Date: April 24, 2018

From: Charles K. Cothorn, P.E.

Subject: Springs at Waterview

This memorandum has been prepared to provide response and clarification to the GMS letter dated February 22, 2018. The comment is listed followed by the response. Please find attached 3 sets of the revised plans for the above referenced project for your review along with a copy of the plat. One of the sets and a copy of the plat has been provided to GMS, Inc. for their review.

ENGINEER:
 DESIGNED BY: JWM DATE: 9/1/17
 DRAWN BY: TGW DATE: 9/7/17
 CHECKED BY: PAK DATE: 5/11/18

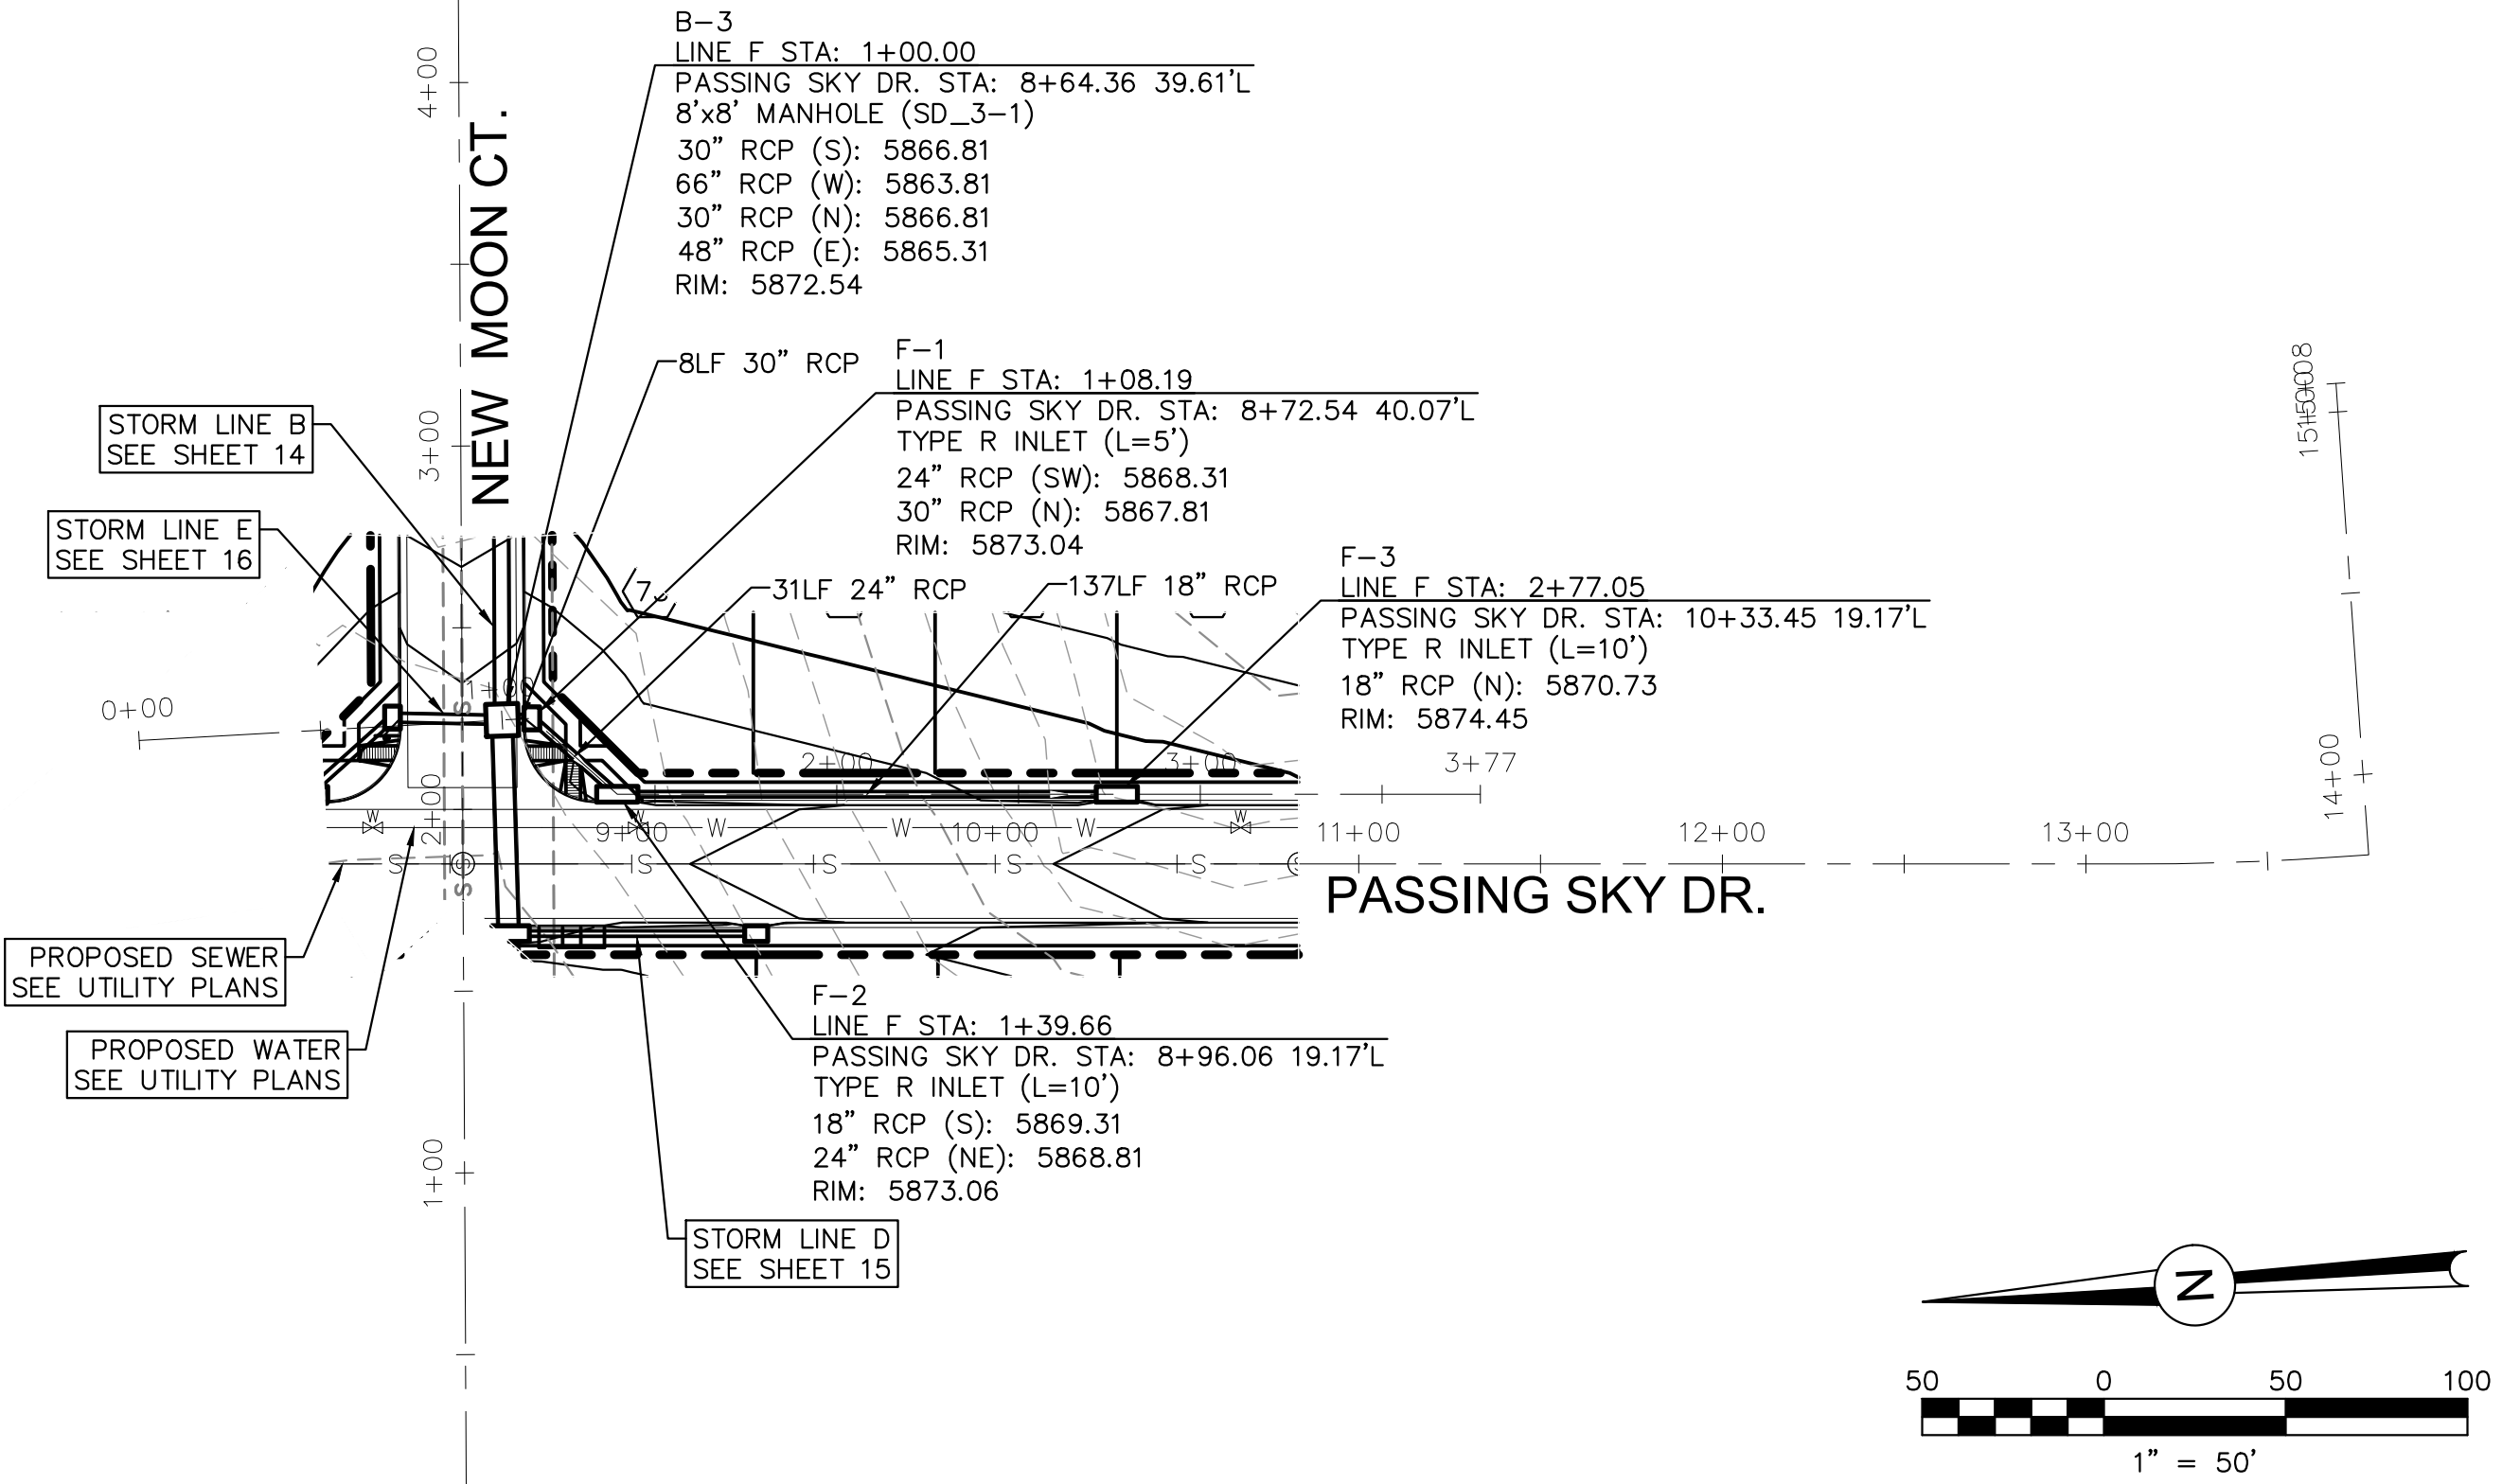
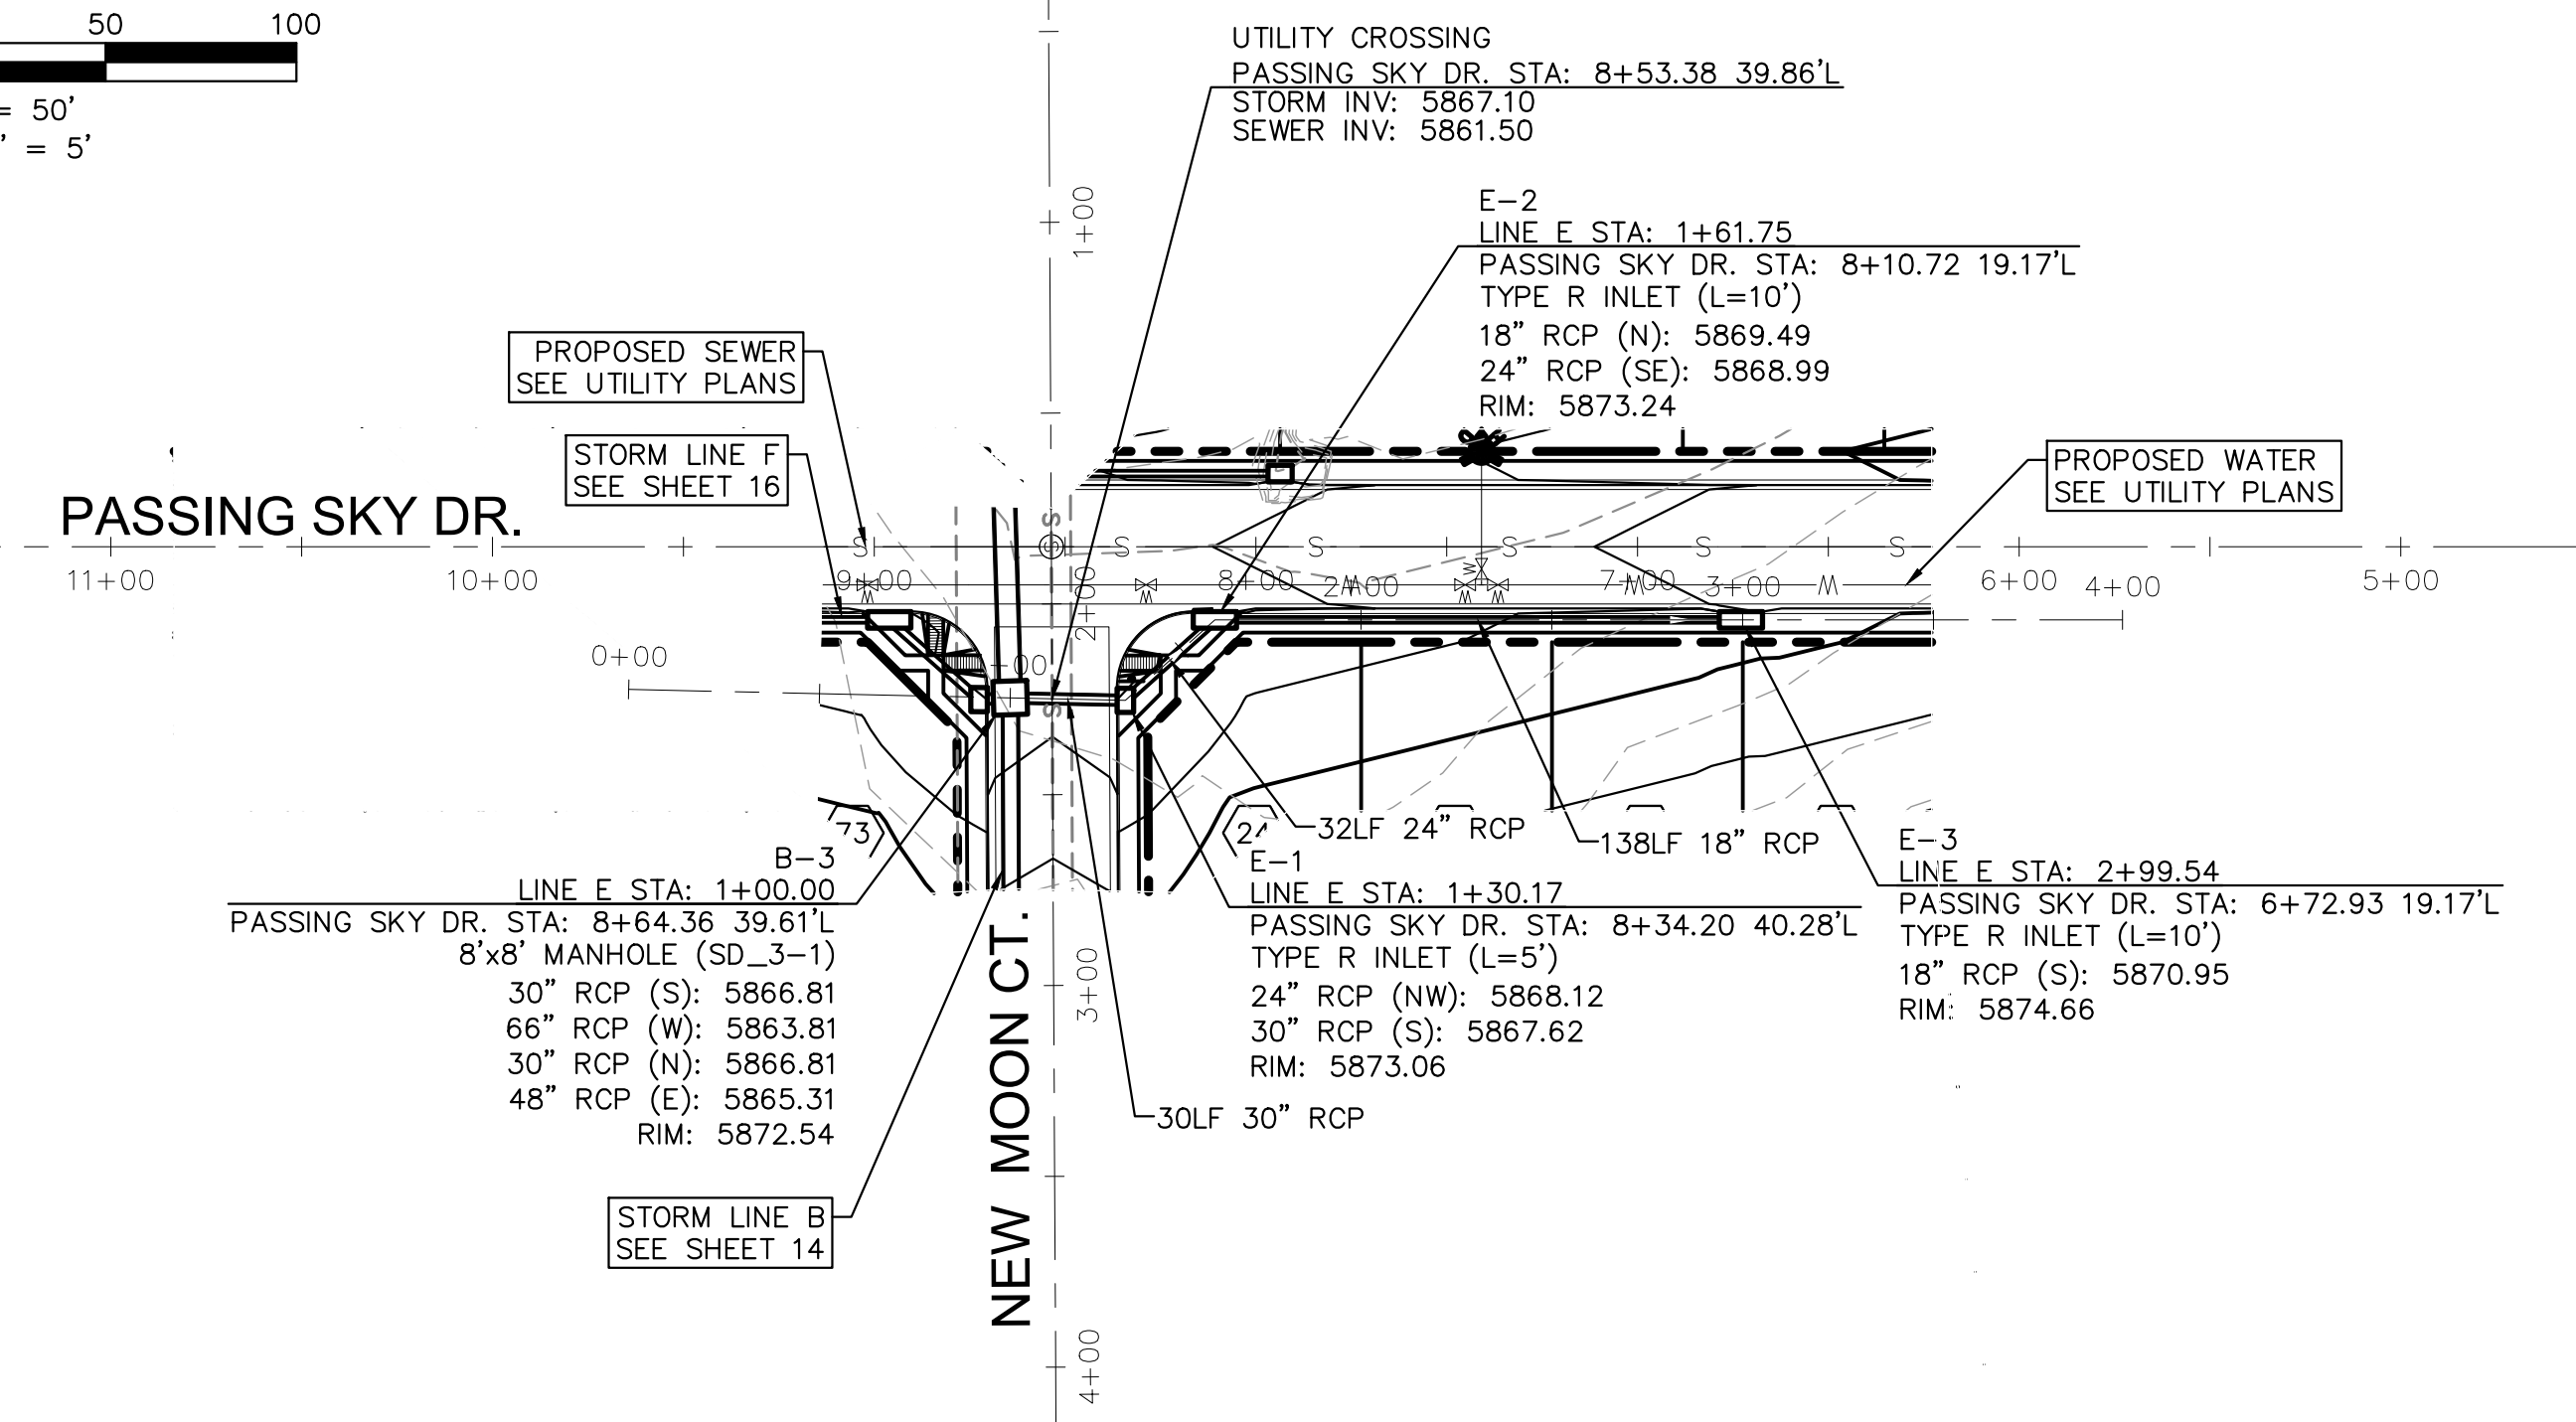
1. In order to comply with District's water service depth requirements and vertical separation requirements from sewers, please provide and indicate the use of water service sleeves where the water services will cross under Storm Lines C and D. Provide complete construction details.

DSE Response: Water service line callouts added to have service sleeves to be installed on Lots 9-10, 24-26, 49-50, and 71-73. Standard detail for sleeved crossings added to Sheet 5 of 11, titled Master Utility Plan.
